ADDRESS:
 ✓ 14370 AIKEN RIDE VIEW

DISAPPROVED
Plan Review
 06/19/2020 3:38:50 PM
 dsdespinoza
 EPC Planning & Community
 Development Department

THE WEIMER ADDITION
14370 AIKEN RIDE VIEW
 COMPUTER FILE # 18-1626

SITE PLAN
 VICINITY MAP
 SITE NOTES

FRONT & LEFT ELEVATIONS

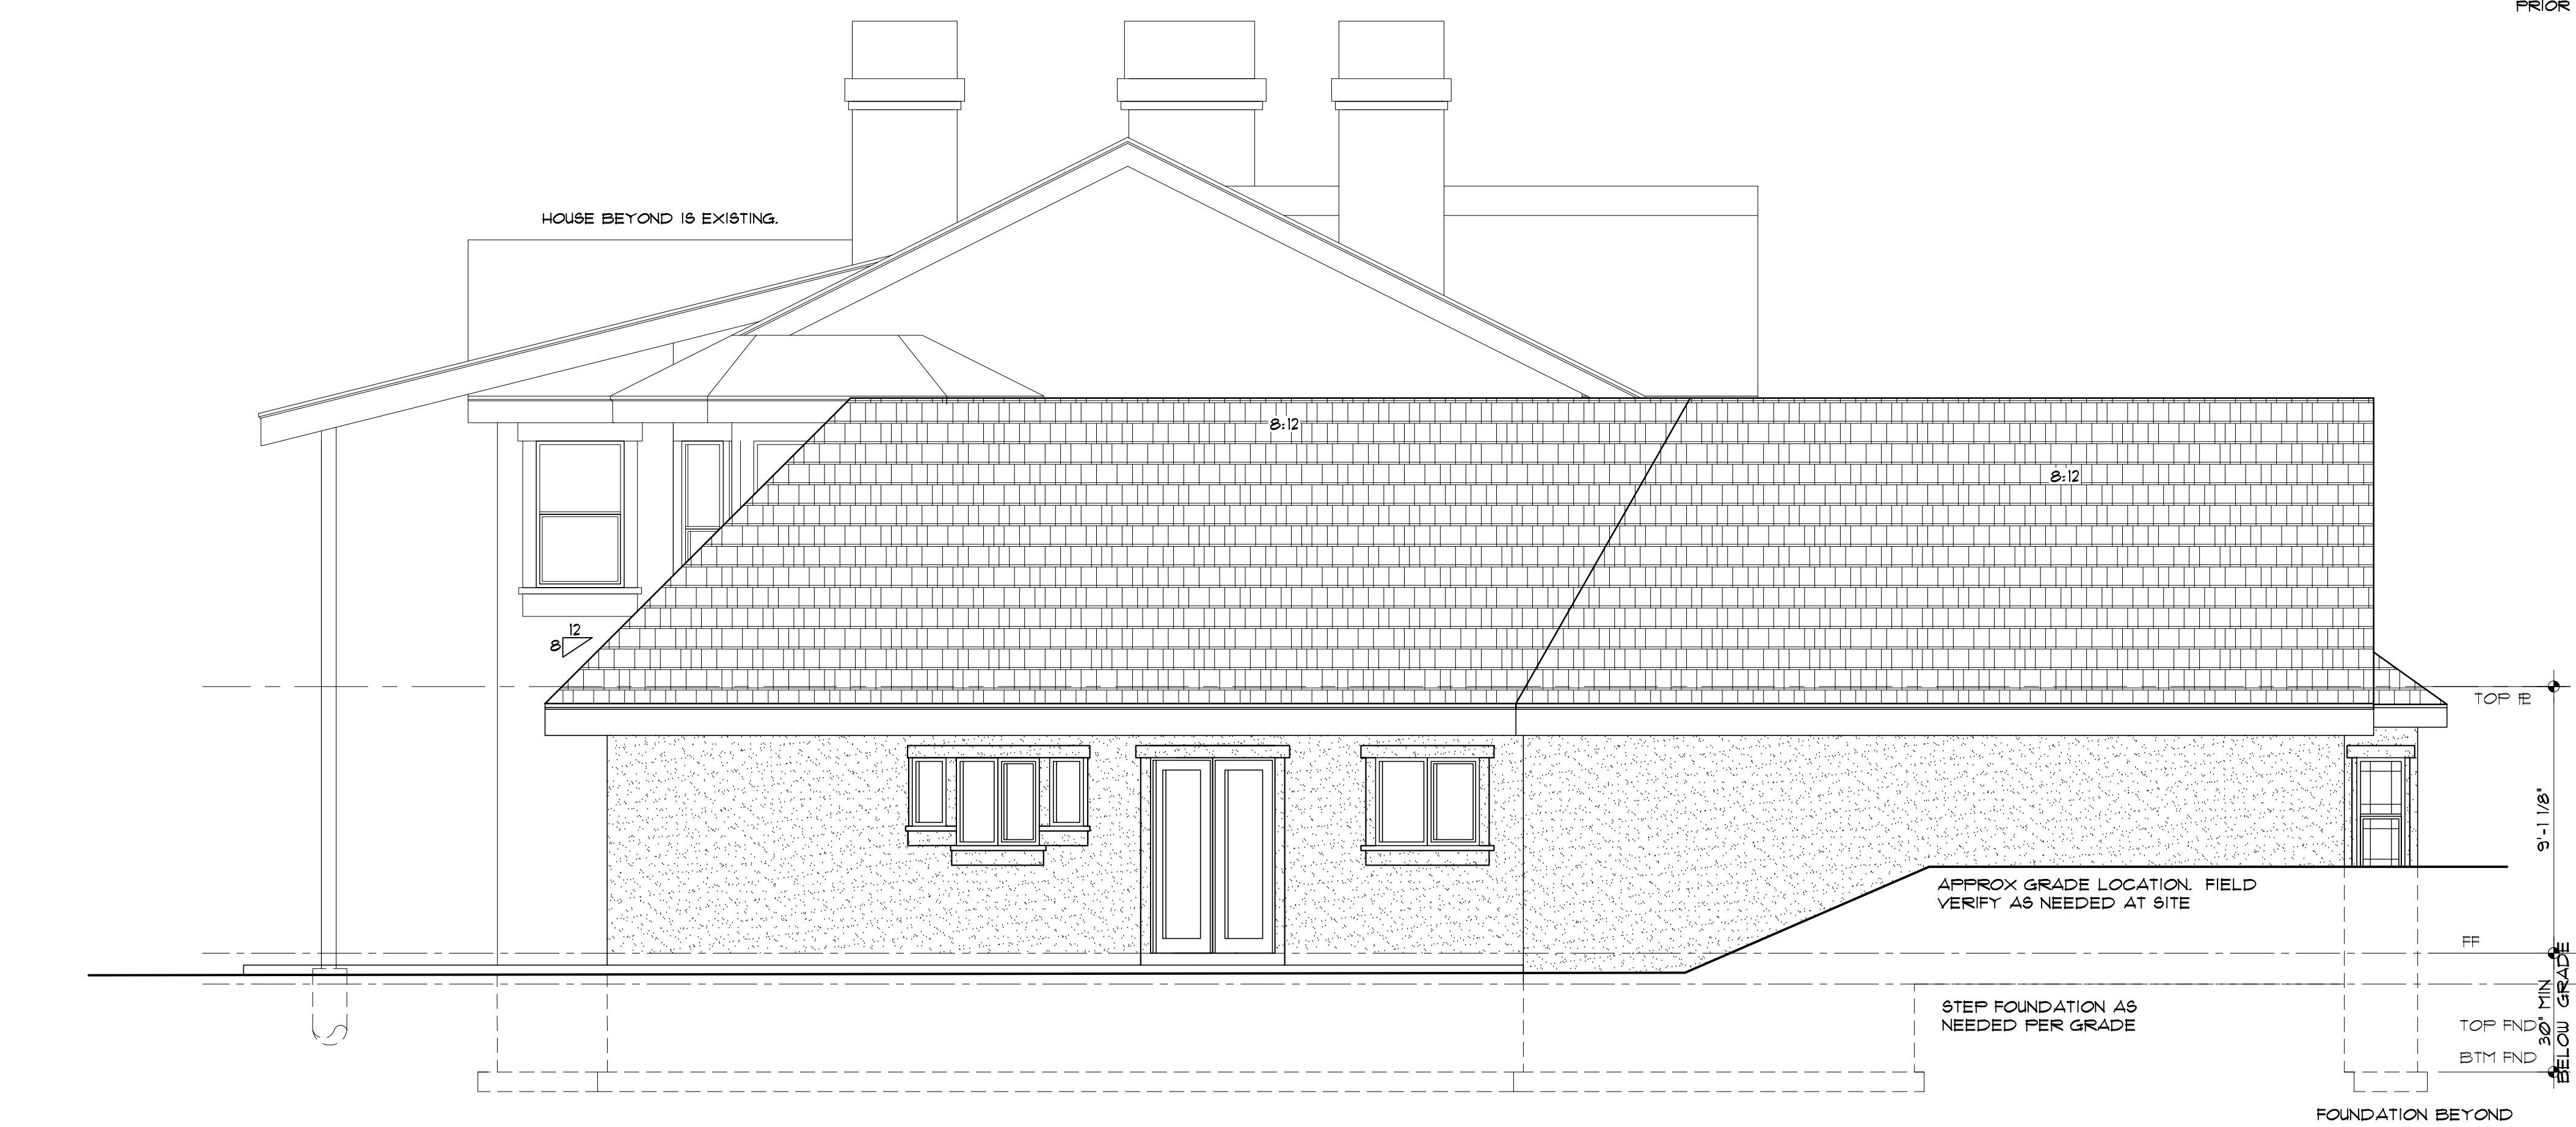
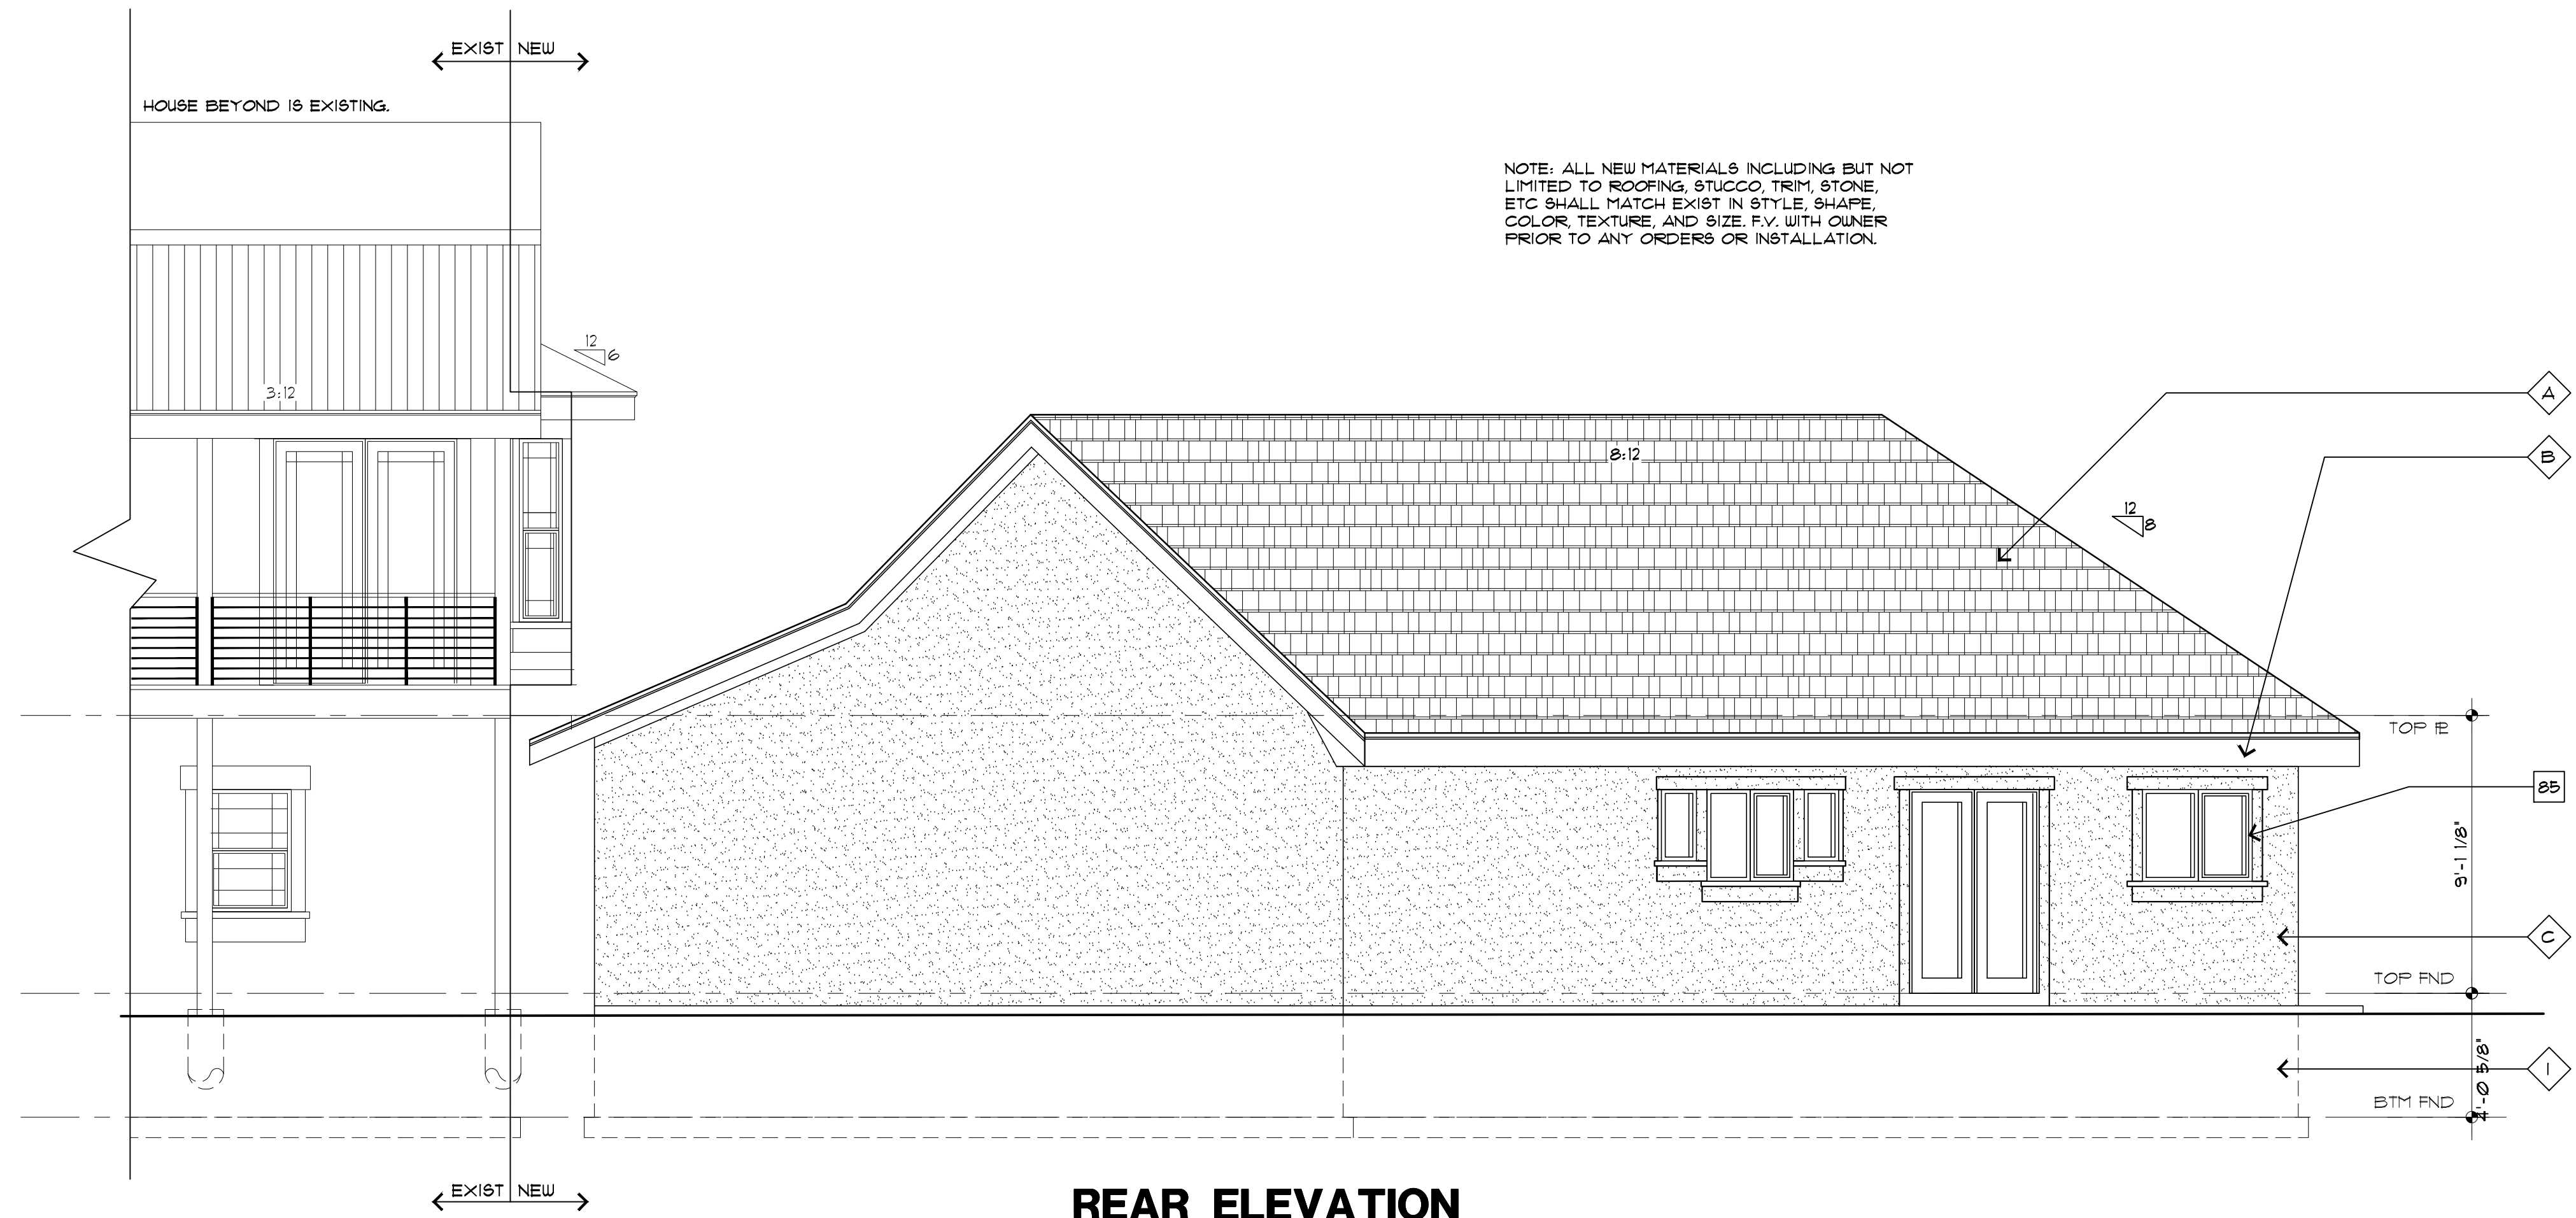
EXCEEDS MAXIMUM ALLOWED HEIGHT OF 30 FT

3. PROPOSED ADDITIONAL ACCESSORY STRUCTURE EXCEEDS MAXIMUM ALLOWED HEIGHT OF 30 FT PER LDC TABLE 5-4: Density and Dimensional Standards for Agricultural, Residential and Special Purpose Districts.
